Please could the attached plan be uploaded to LU/249/19/PL, as per action sheet

Richard Castro-Parker
Senior Planning Officer (Contract)
Arun District Council

I note that the proposed floor plan for the proposed change of use to Adult gaming centre and betting office shows the rear of the premises as remaining as retail area. I Take it that this is meant to form part of the adult

No.48 PROPOSED GROUND FLOOR PLAN | 1:100

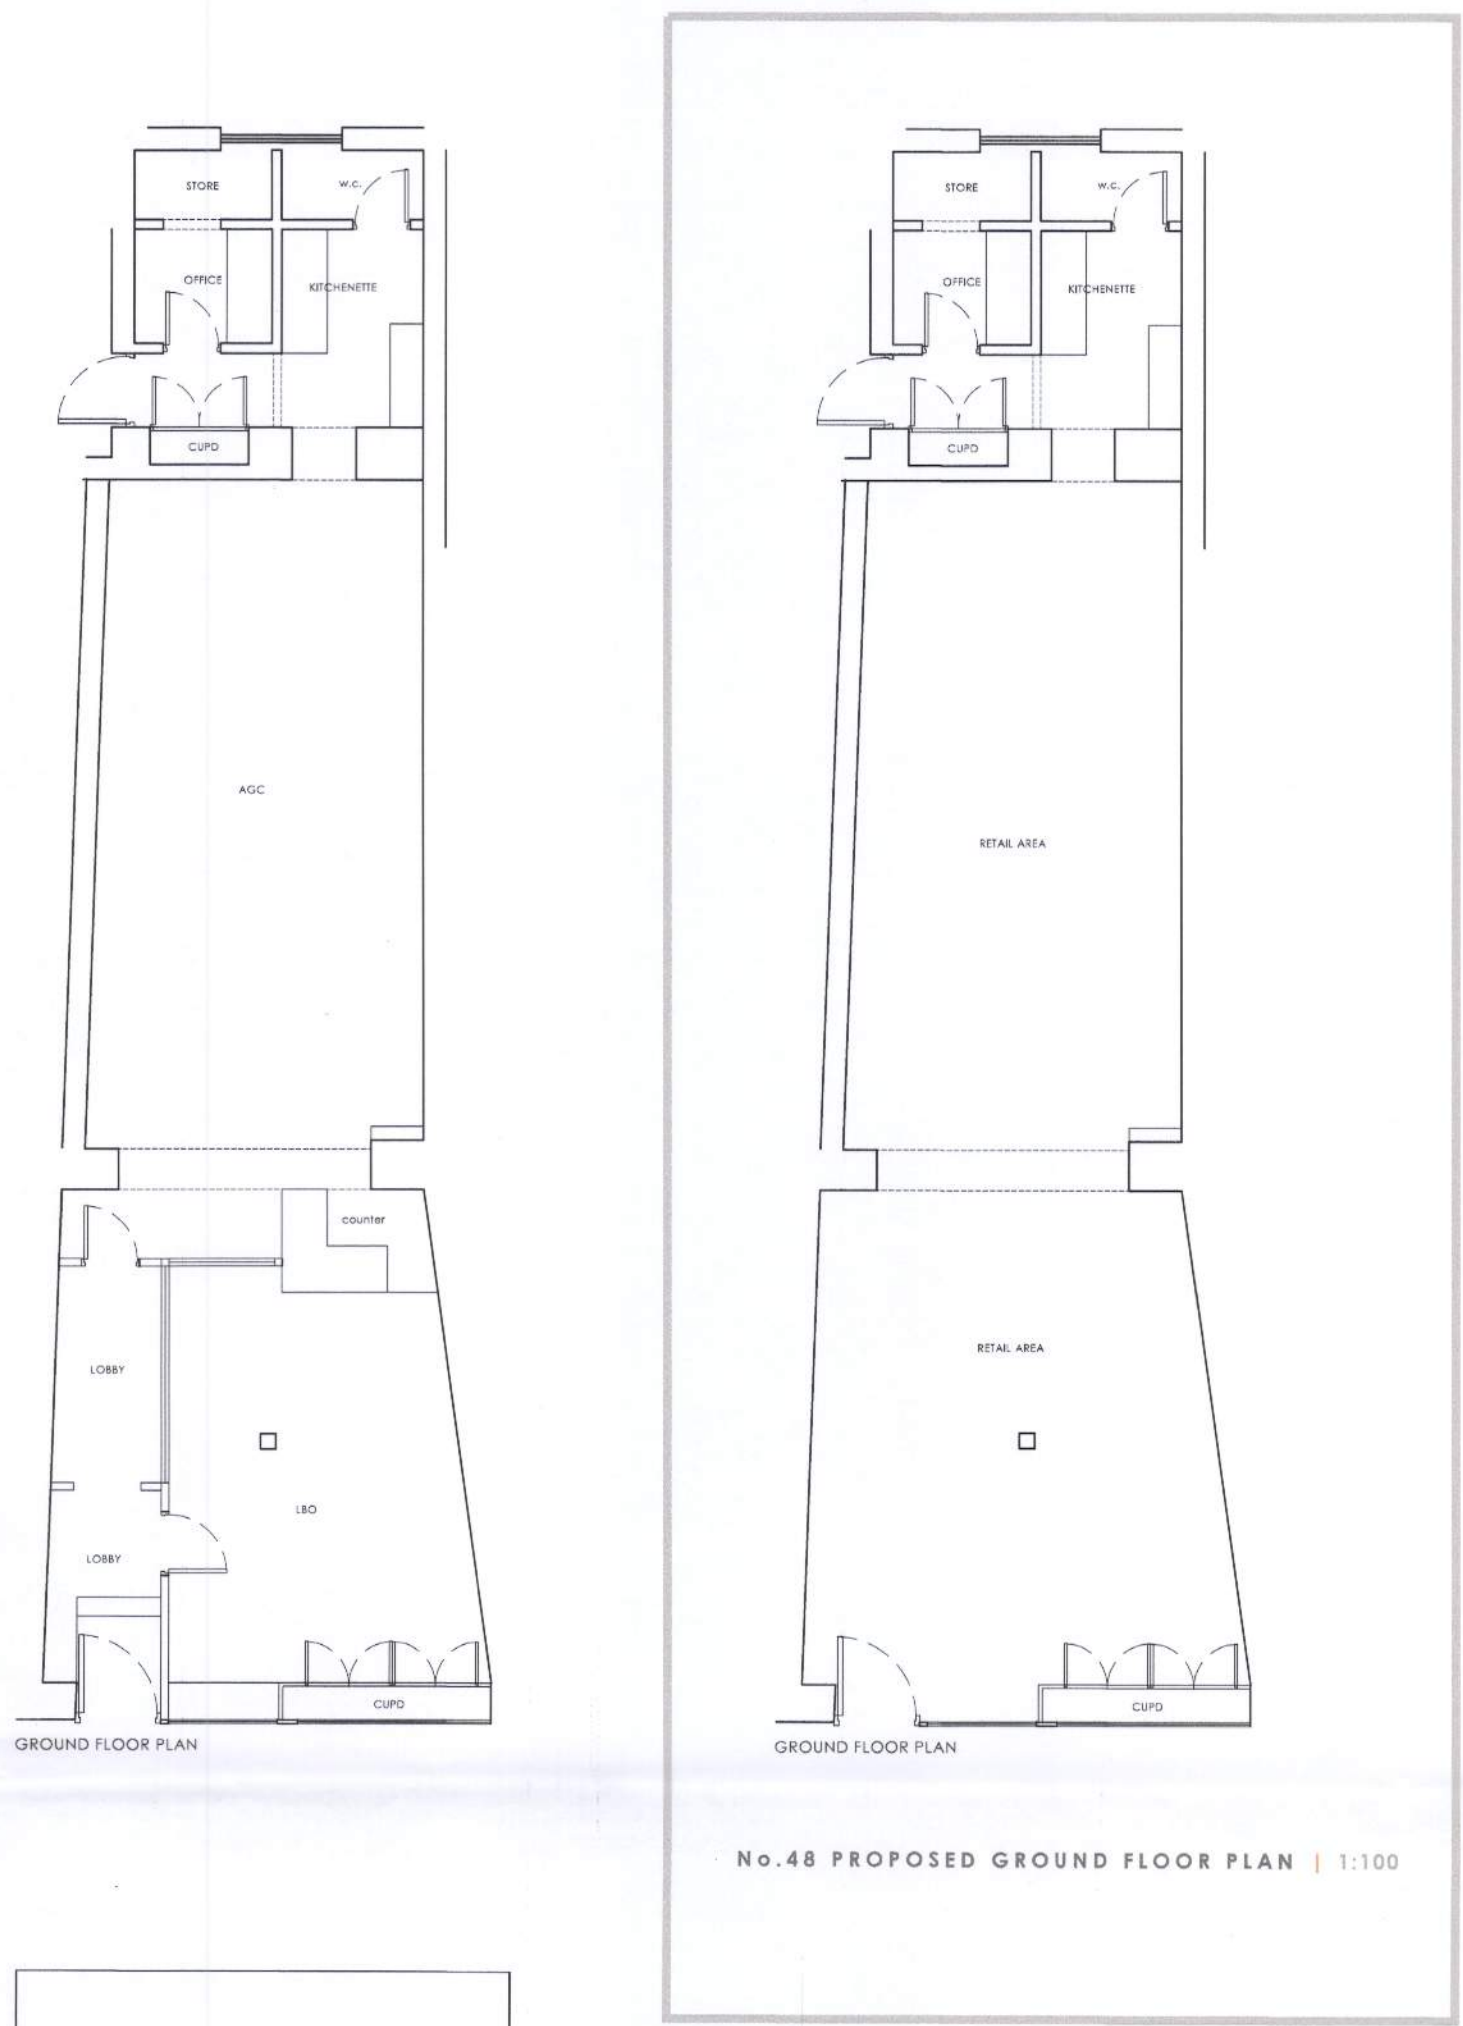
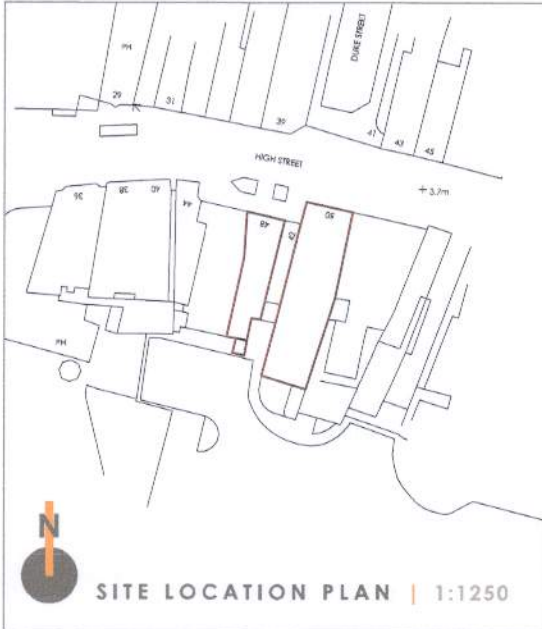
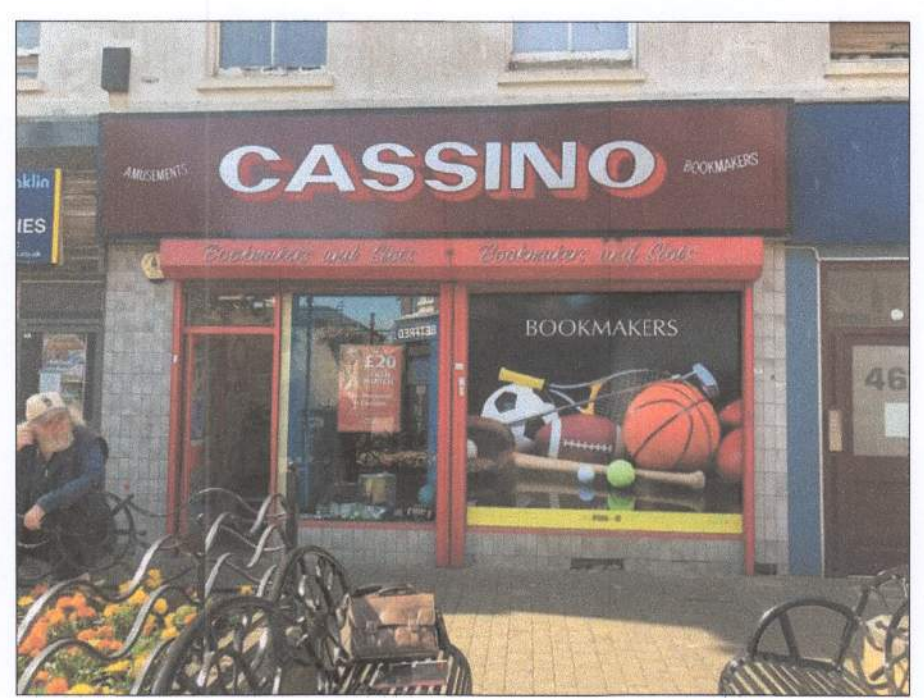
gaming centre use. Please can you confirm if this is the case or not. If this is the case please could you amend the plans to remove the reference to retail area on the proposed floor plan. I am currently writing this application and would like to pass this across to the Area Manager for sign-off this week (or as soon as amended plans are received).

Please find attached amended plan as requested. I also agree to the extension of time until 6th December.
